Fire Marshal Division

**RE: Harnett County DSS Addition
311 W. Cornelius Harnett Blvd.
Lillington, NC 27546**

Re: Application Number – FMFW1908-0010

SHEET TITLE: LIFE SAFETY PLAN - LEVEL 01

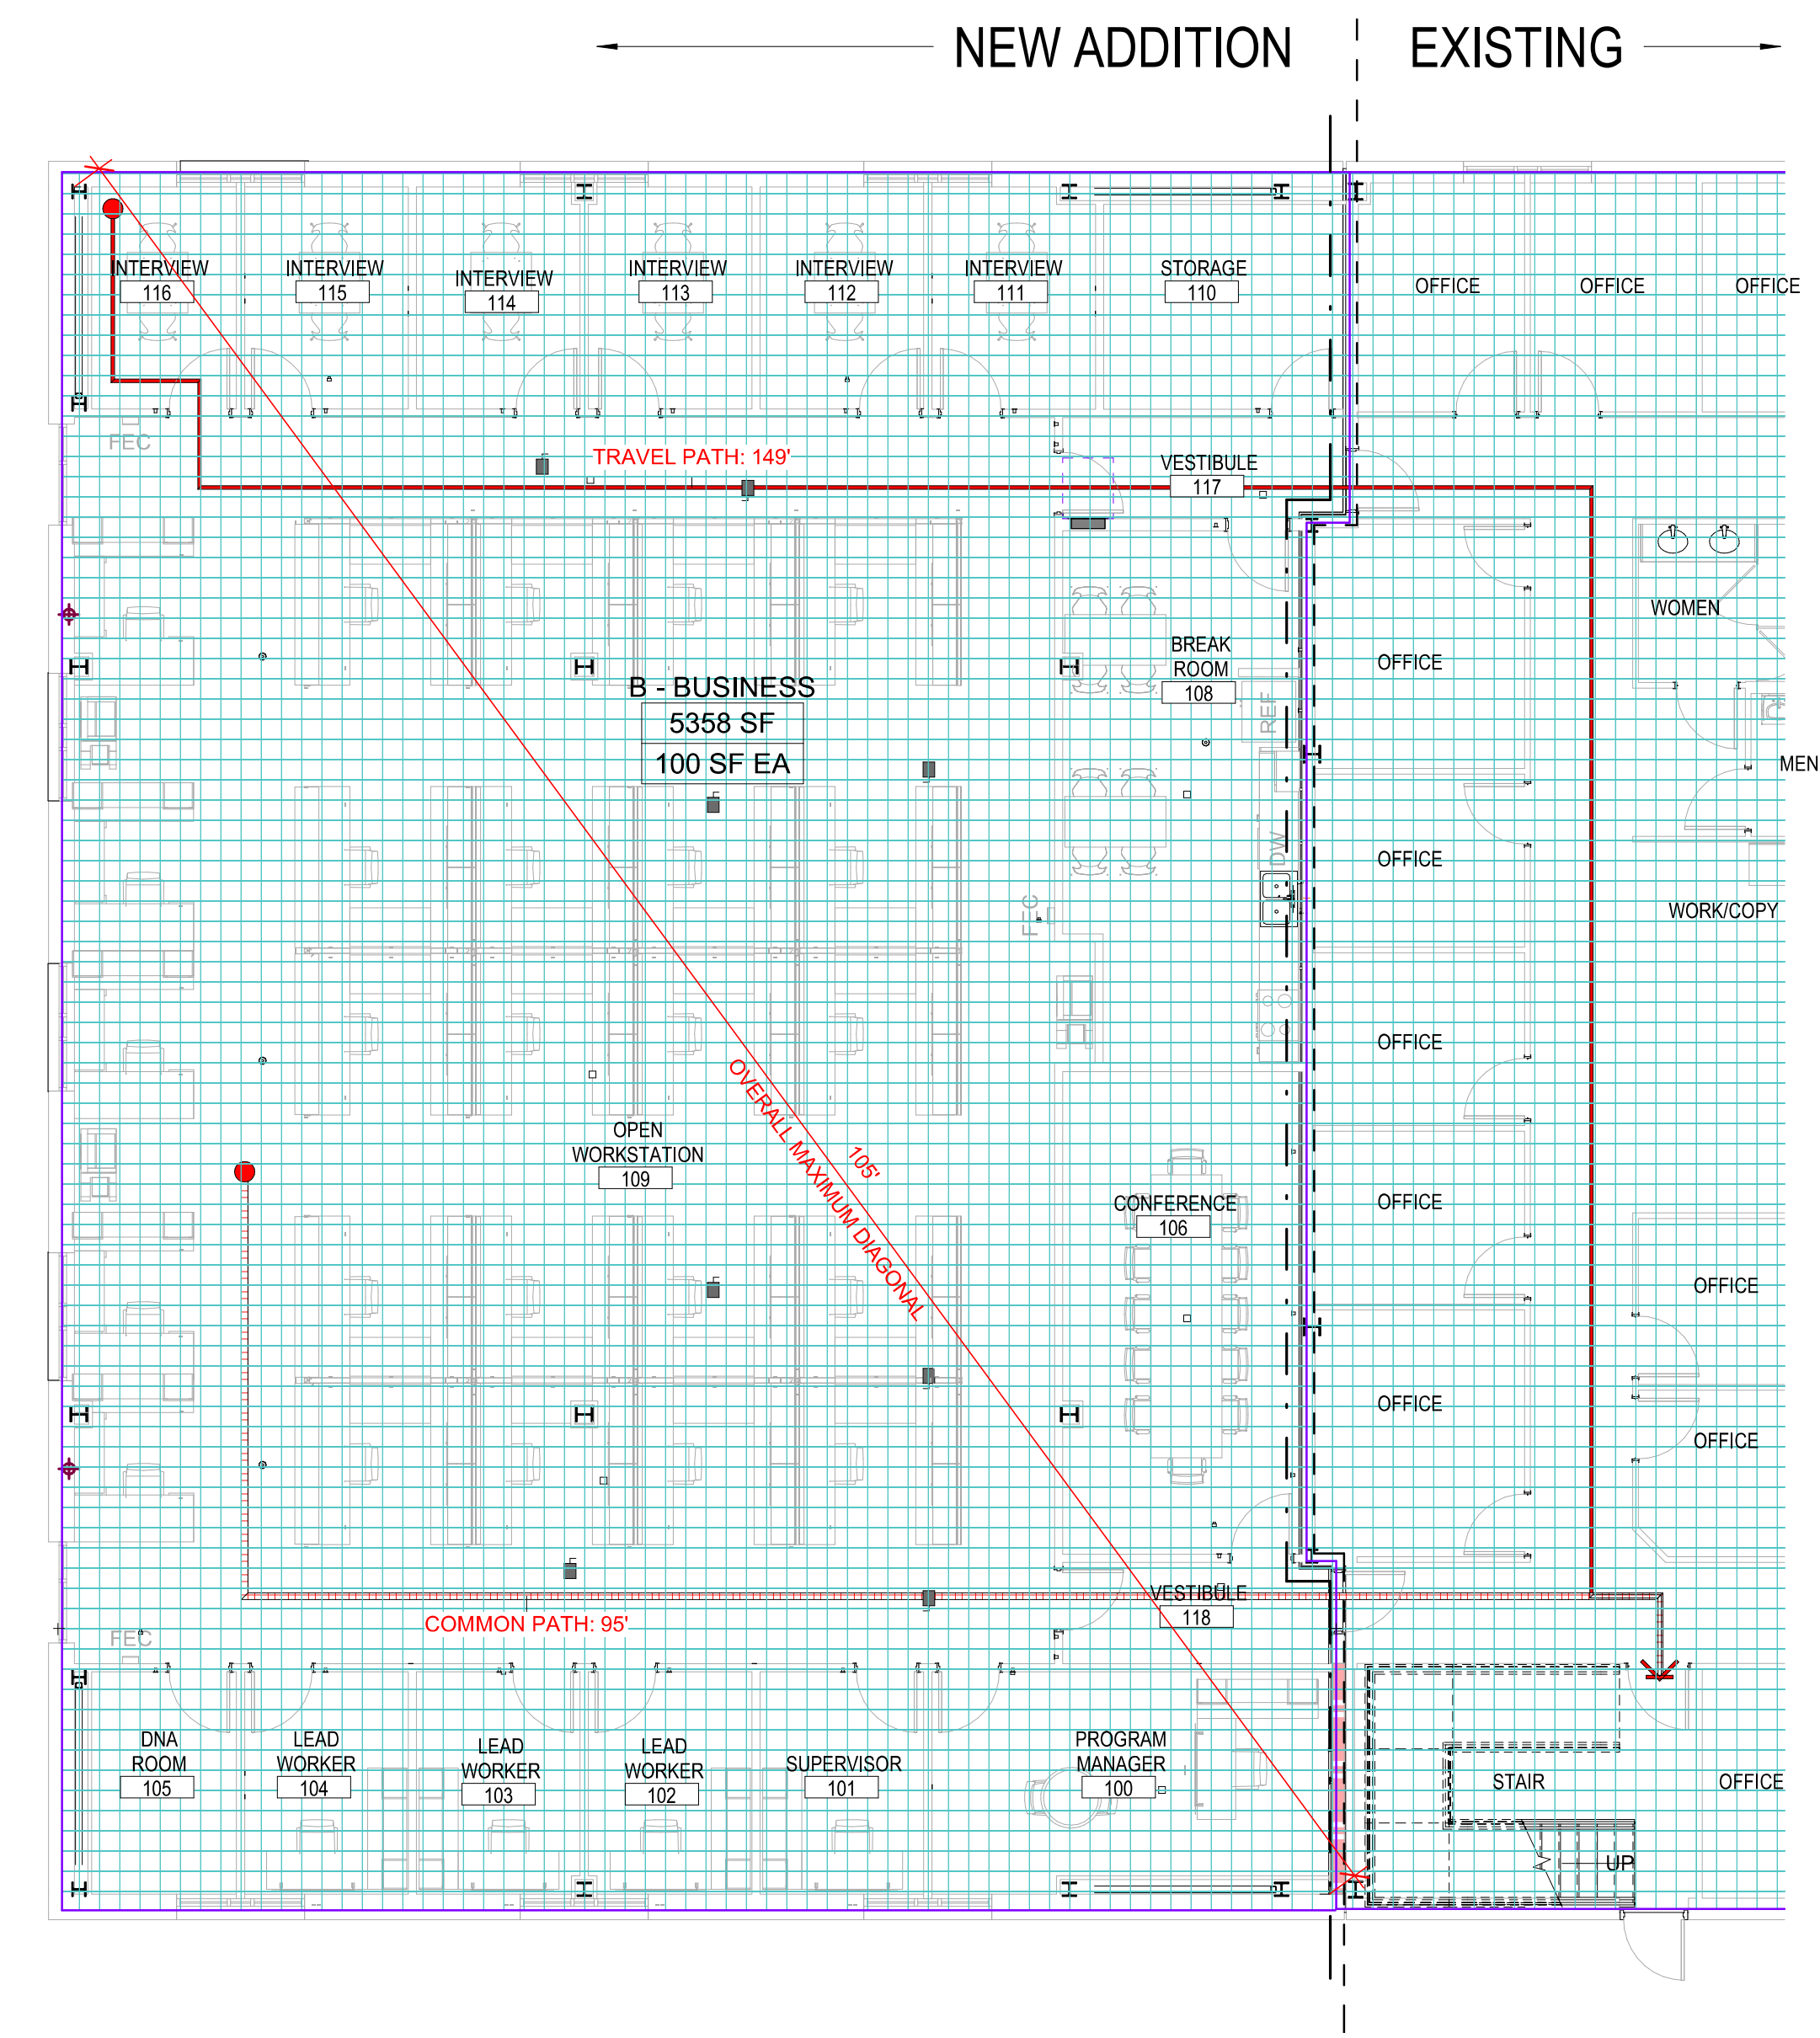
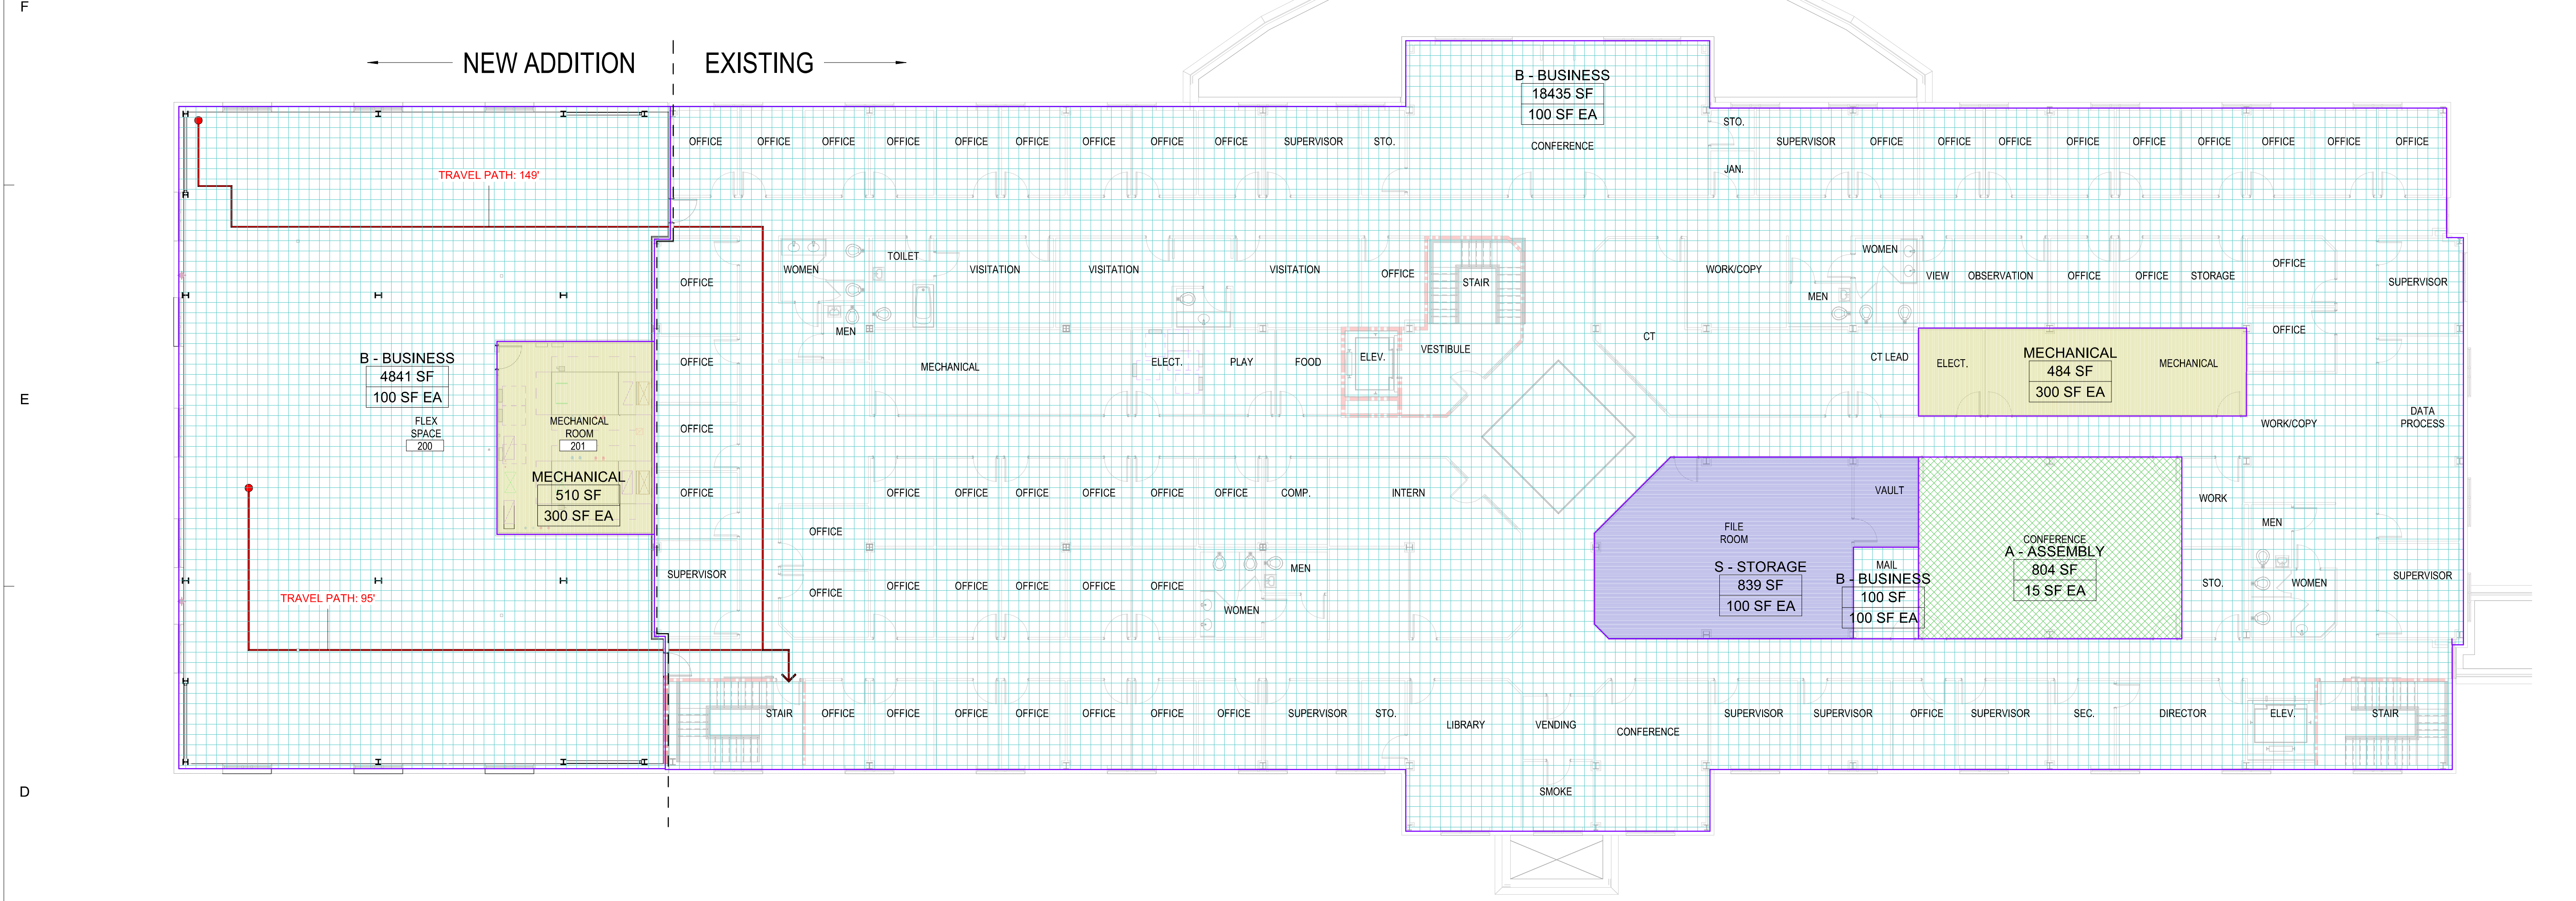
- **Notes**
 - Please clarify the existing building's design occupant load utilizing the stairwell as an exit, and the main exit level discharge being utilized for the new addition. While occupant loads are shown for the addition, calculation of totals based on the existing building are not shown.
